**RE: Transmittal of Comments – Hansen Short plat, (SP-13-00007)**

RE: Hansen SP-13-00007

Thank you for the opportunity to comment on the Hansen Short Plat, SP-13-00007.

**HANSEN SHORT PLAT
 PART OF SECTION 8, T. 17 N., R. 18 E., W.M.
 KITITAS COUNTY, WASHINGTON**

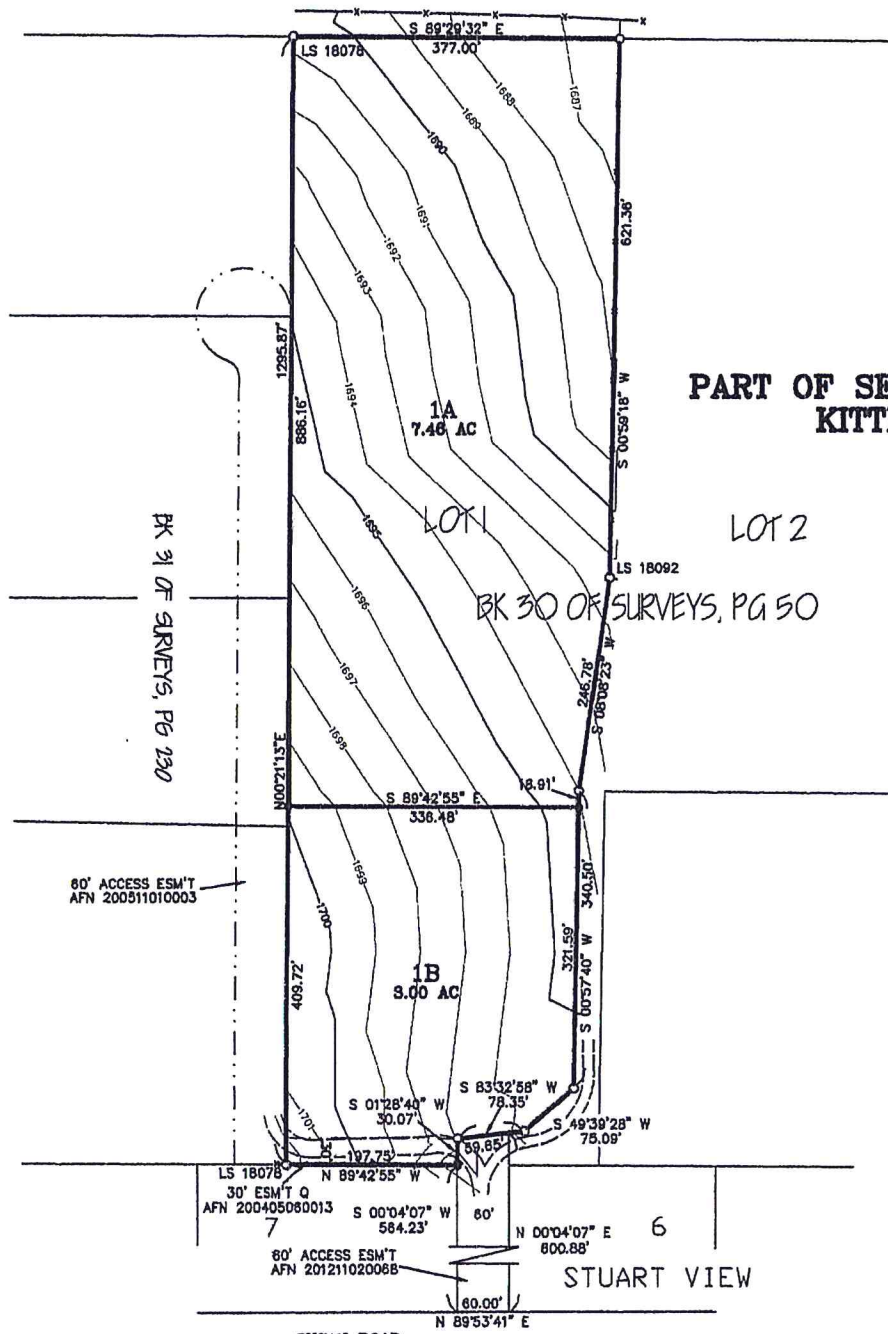
The proposed Short plat will require a minimum of one soil log or site evaluation on each proposed lot. It appears that there are no wells located on either proposed lot, you will either need to drill a well on each lot or drill one well on a lot and provide a recorded shared well users agreement along with the other requirements. The above mentioned requirements need to be satisfied and the appropriate

documentation needs to be submitted to KCPHD for review and approval in order for the plat application to be recommended for final approval.
